14 March 2014

Re: SSD 4972 – SECTION 96 MODIFICATION NO.2, FOUR POINTS BY SHERATON  
HOTEL EXPANSION, 161 SUSSEX STREET, SYDNEY.  
REF NO.: SSD 4972 MOD 2

Drawing Title: **SLIP STREET EAST ELEVATION**
Drawing Number: **A-DA-0304**
REV: **G**
Scale: **1:200 @ A0**

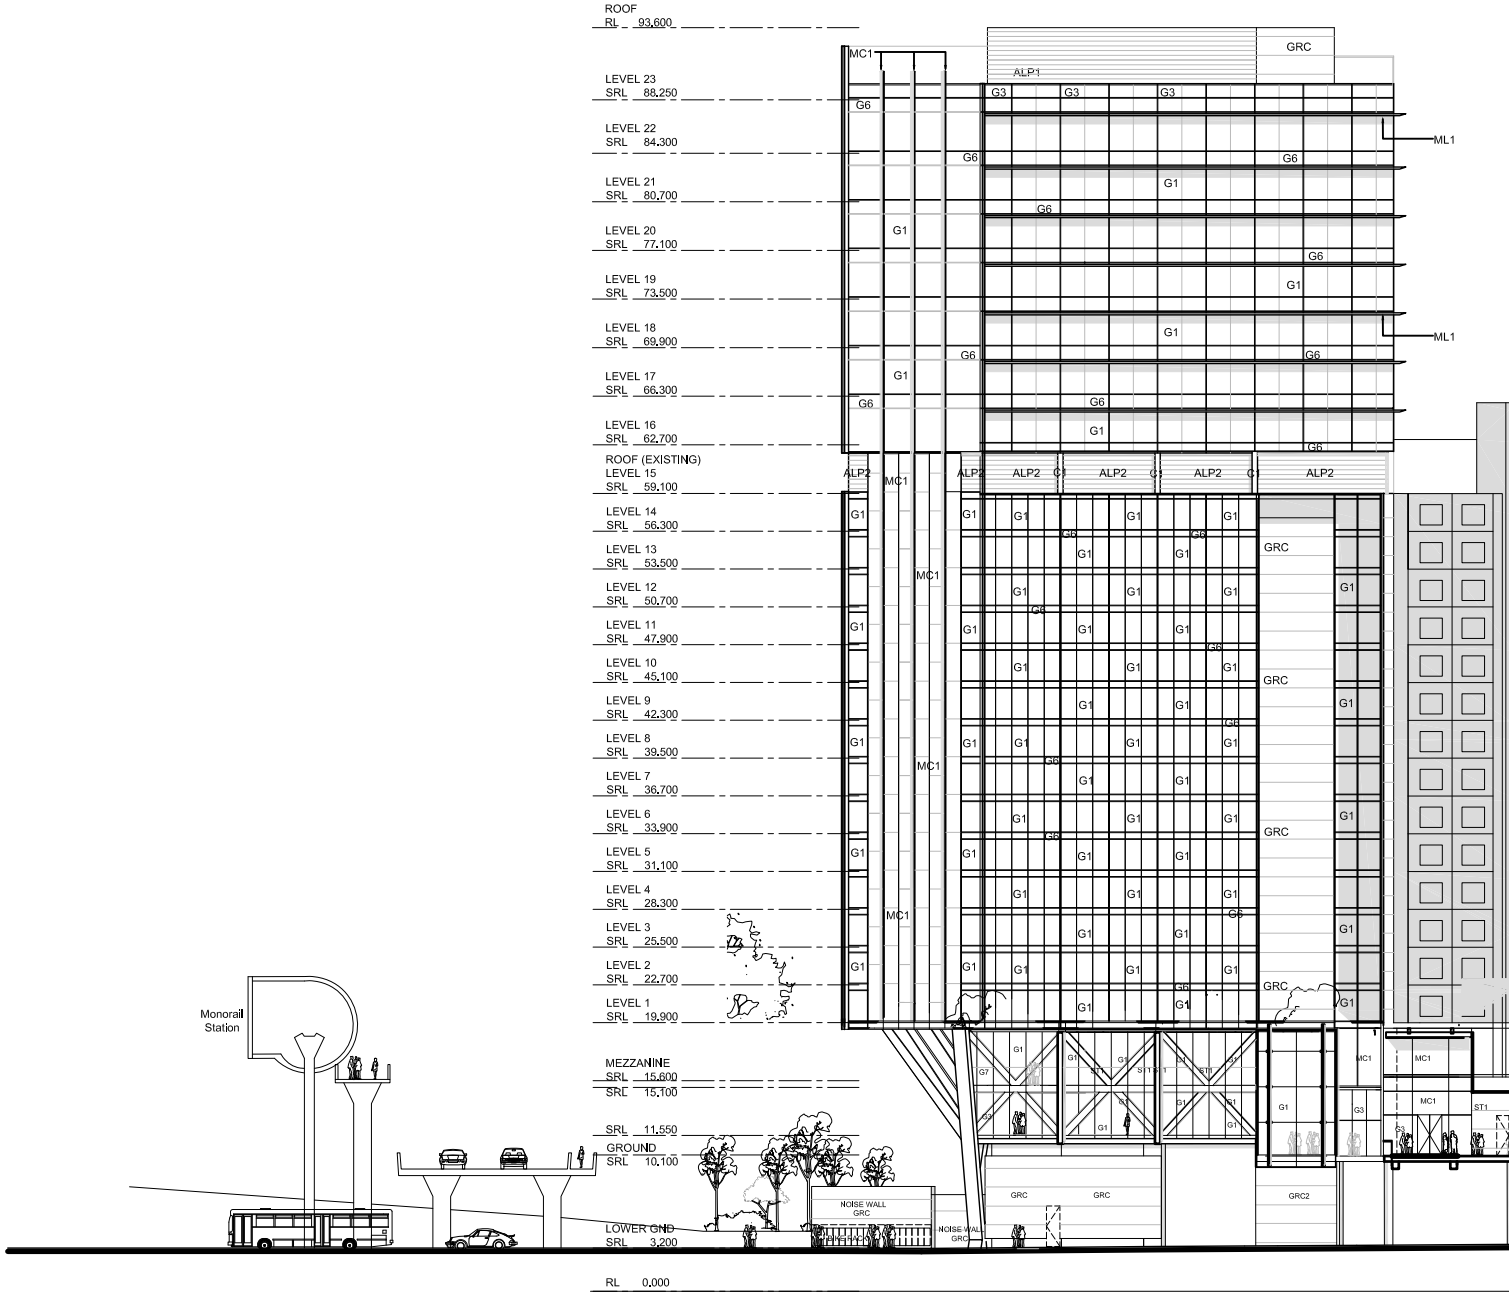
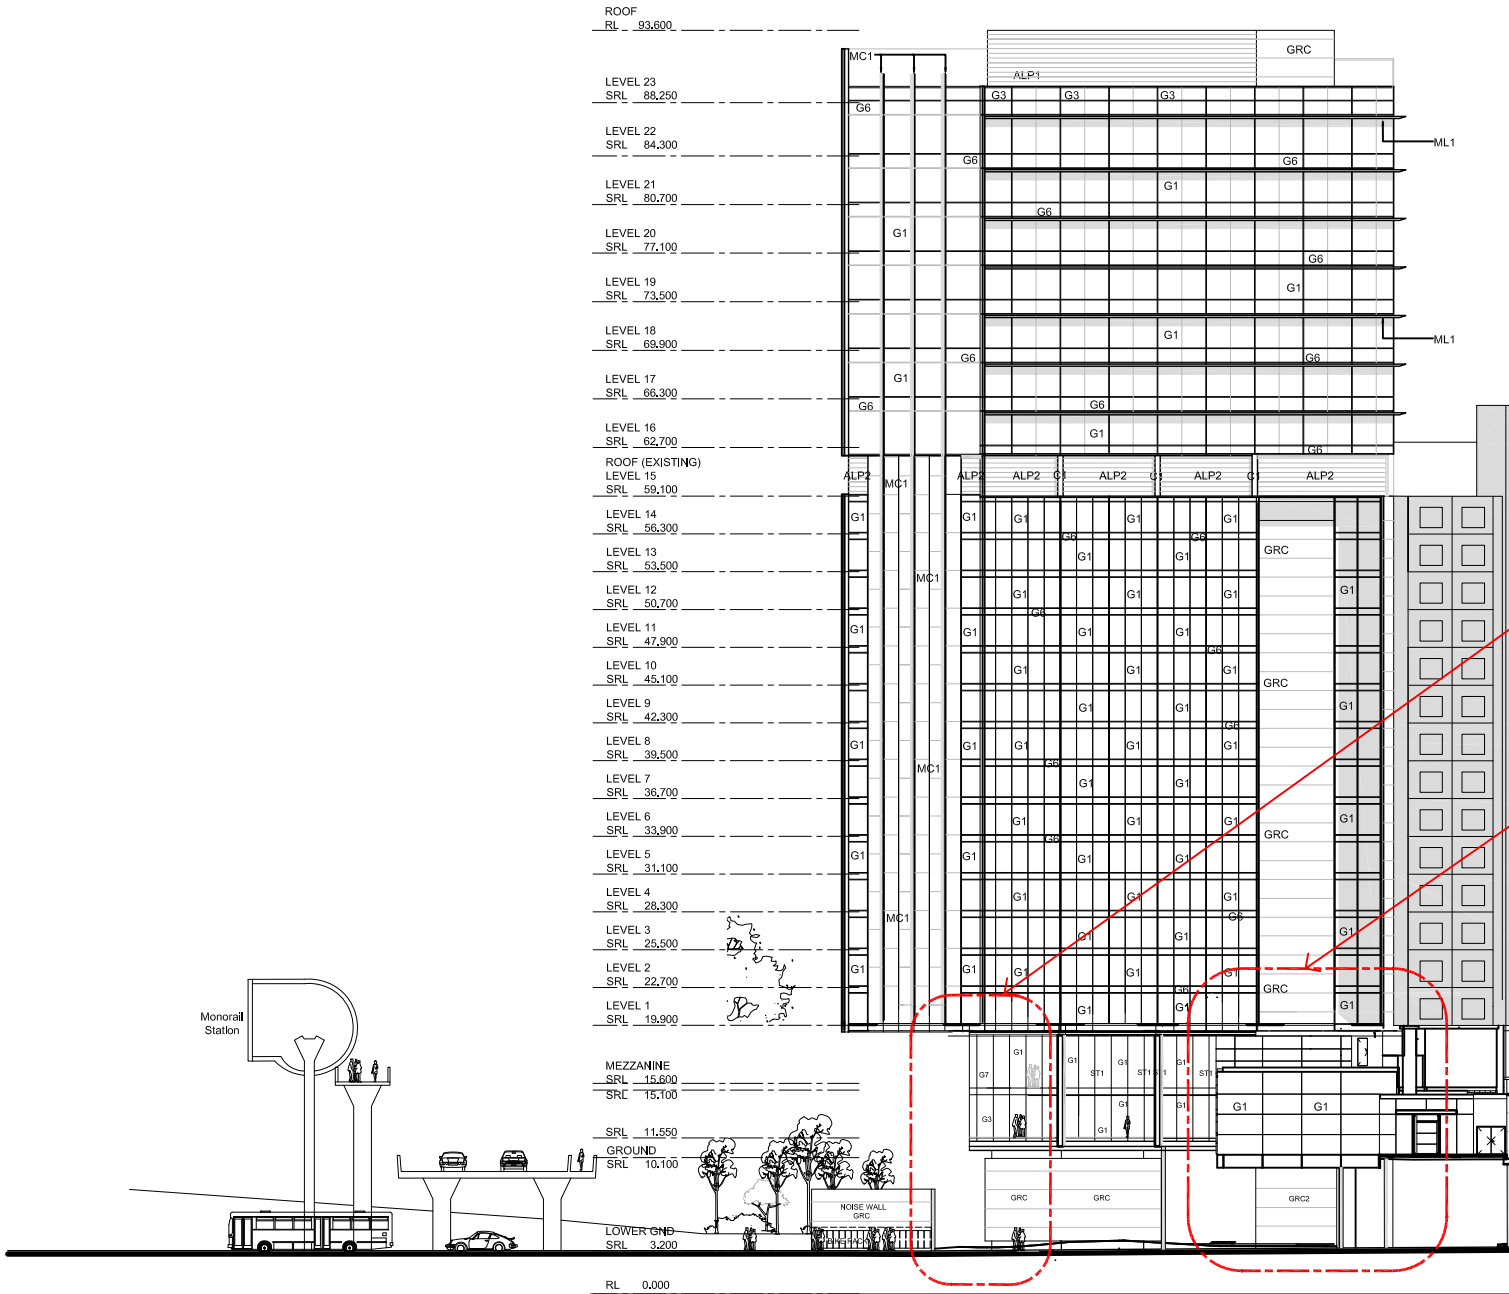
The proposed changes are significant departures from the initial design of the exposed support structure. The initially proposed angular 'V' columns and trusses were considered an important part of the design expression. The structure allowed for the building above to "float" over the Slip Street below which enhanced the architectural expression of the proposed building. Furthermore the proposed modification is unclear on how the varied structure impacts on the ground plane.

the (heritage listed) Corn Exchange building. Based on the available documentation (i.e. reduced plans and elevations), it is difficult to examine the design variation and ascertain the actual impact of this proposed variation. A detail plan of the ground/ street level should be submitted to ascertain the impacts of the proposed modification.

PUBLIC DOMAIN PLAN LOWER GROUND

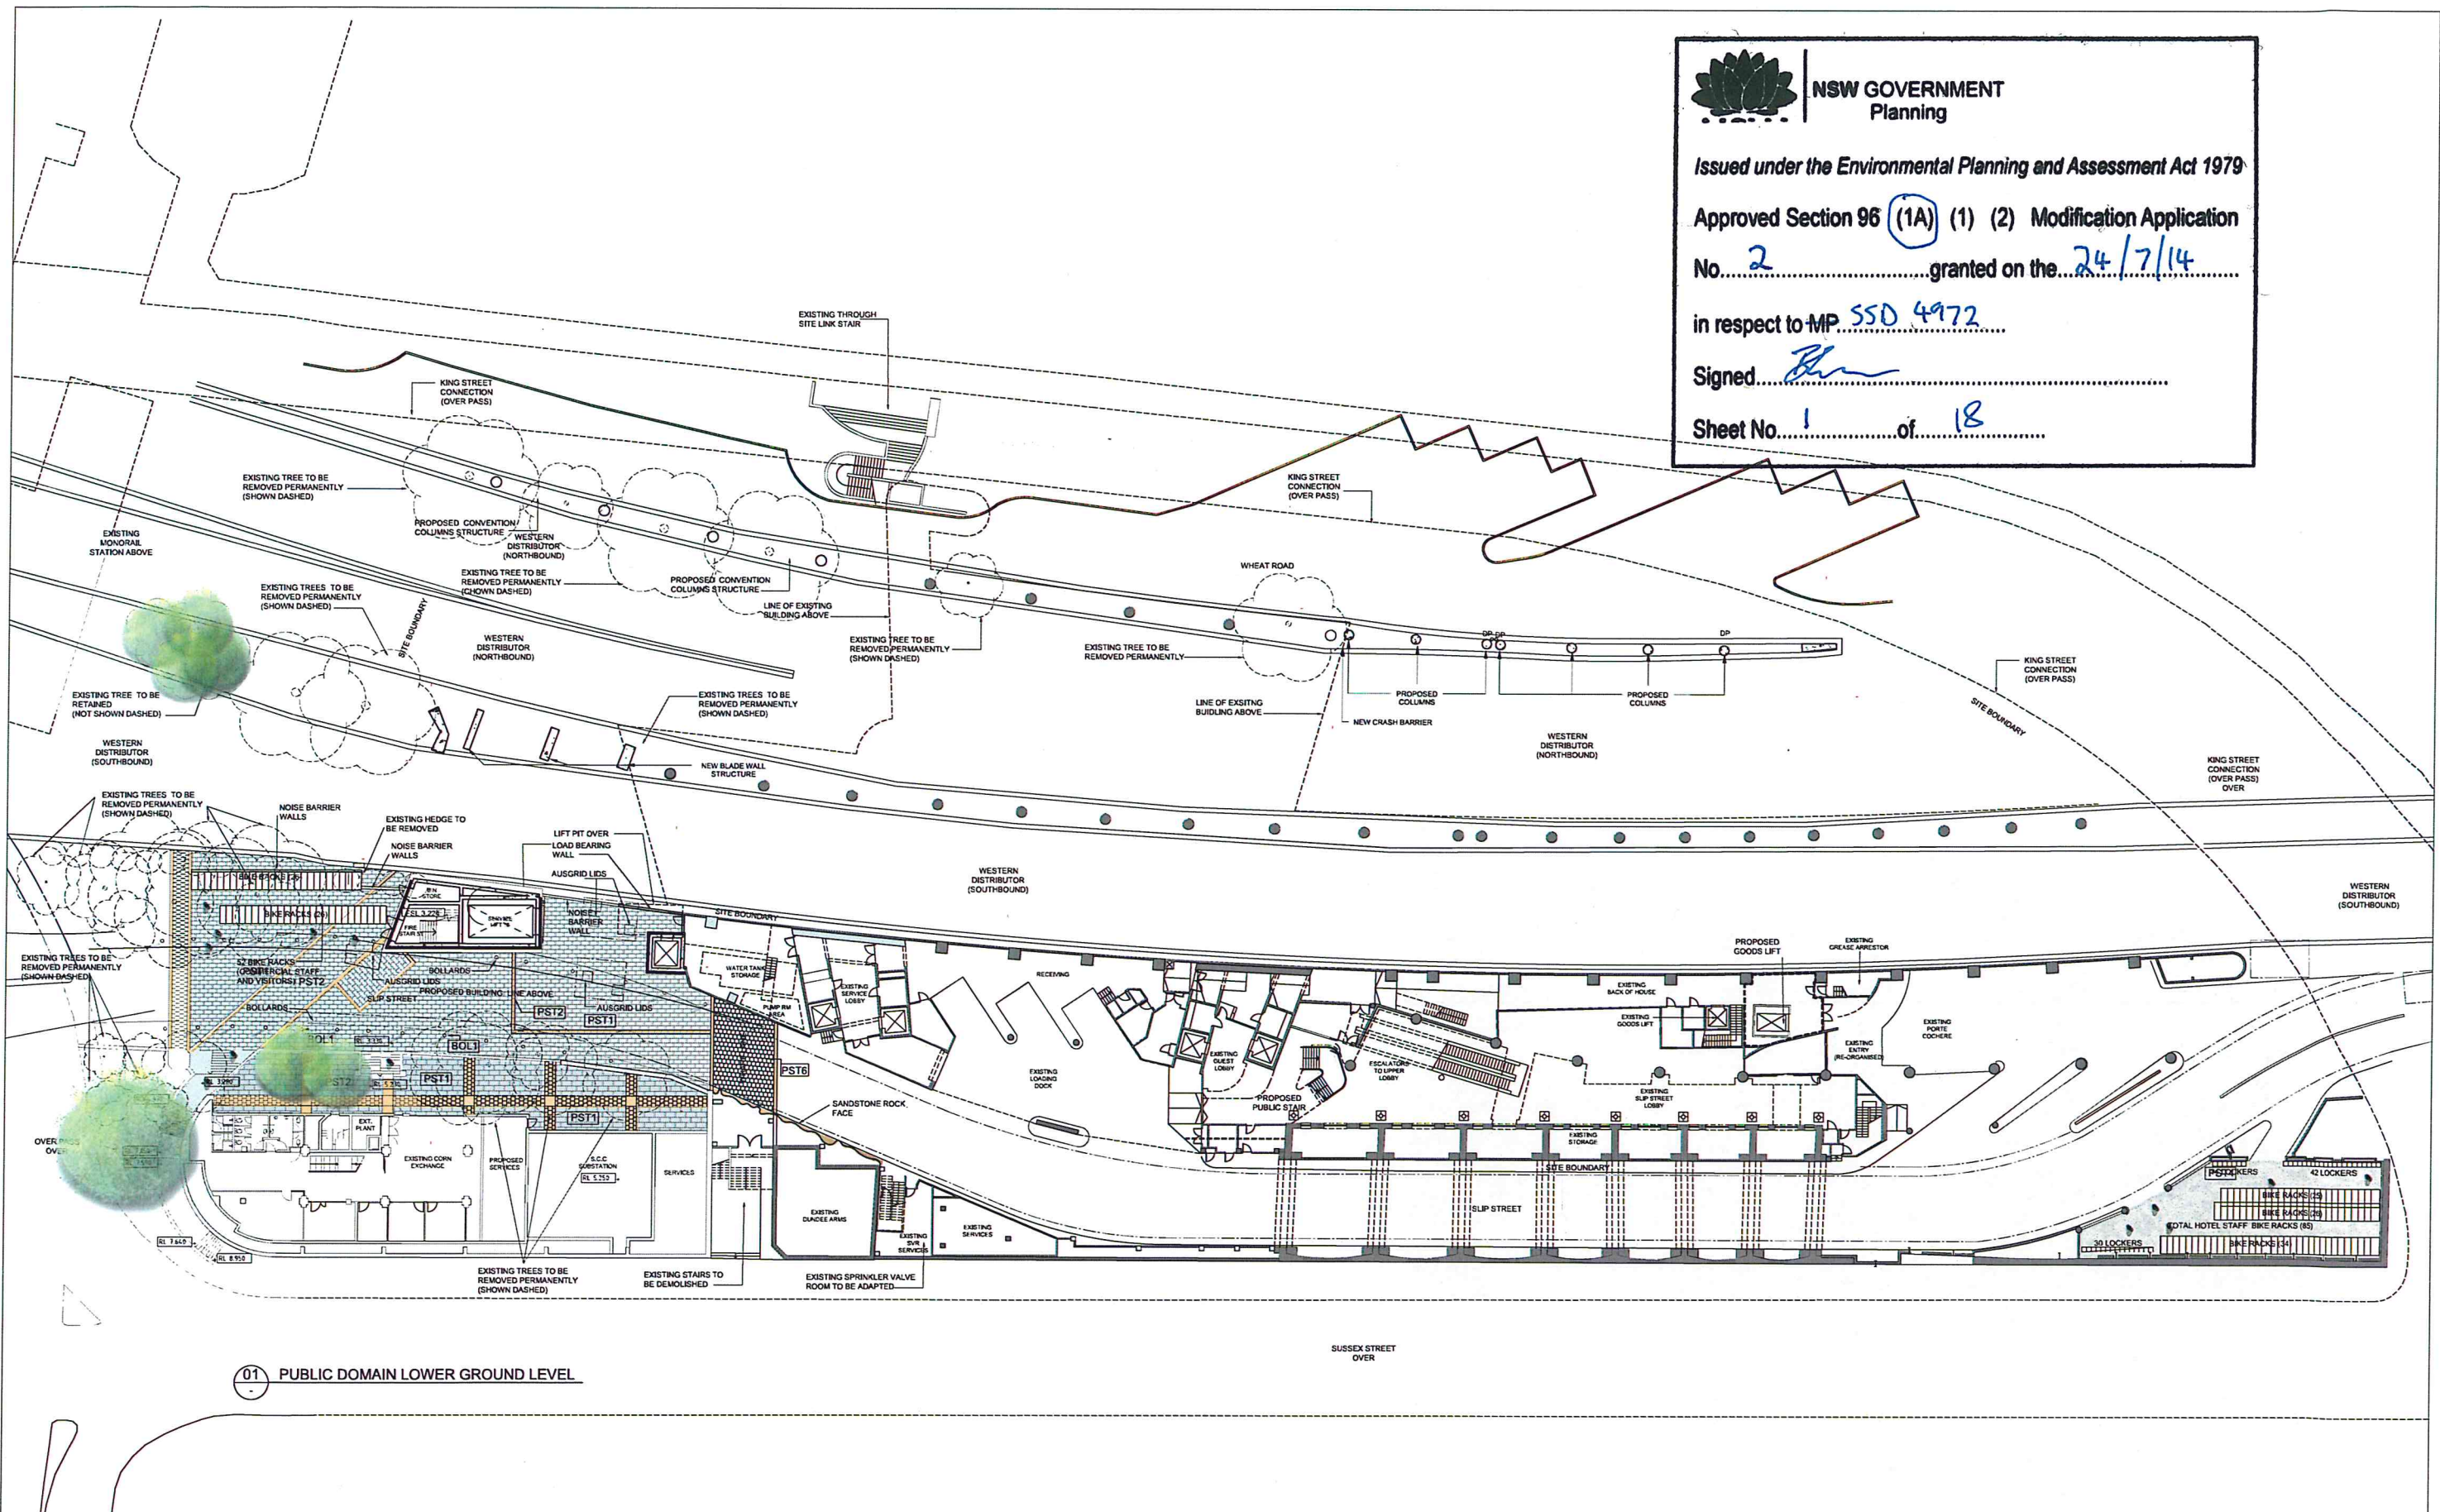
A number of issues arise in relation to landscaping. The first issue is the proposed removal of a number of existing trees, between the proposed new tower and the Corn Exchange, considered necessary due to installation of electrical pits in this location. Removal of mature and established trees will result in significant loss of amenity and insufficient information is provided to demonstrate:

- a. If and how alternative locations have been assessed and precluded for the electrical pits and
- b. If in fact the trees are to be removed, how the amenity of the space can be improved (e.g. with more planting post construction)

- I. reporting existing trees condition
- II. report on how the trees will not survive the proposed works
- III. if it is intended to replant new trees upon completion of the works, to specify appropriate location, setting and species.

The second issue is in relation to the electrical pits. It is unclear if the proposed pits were part of the original submission. The information provided is insufficient to determine if the proposed pits will present an adverse impact on the adjoining state heritage listed items, or the archaeology of the site.

We recommend that the Heritage Impact Statement and the Archaeological Assessment Report for the site be amended and resubmitted to address the potential impact of the proposed works.
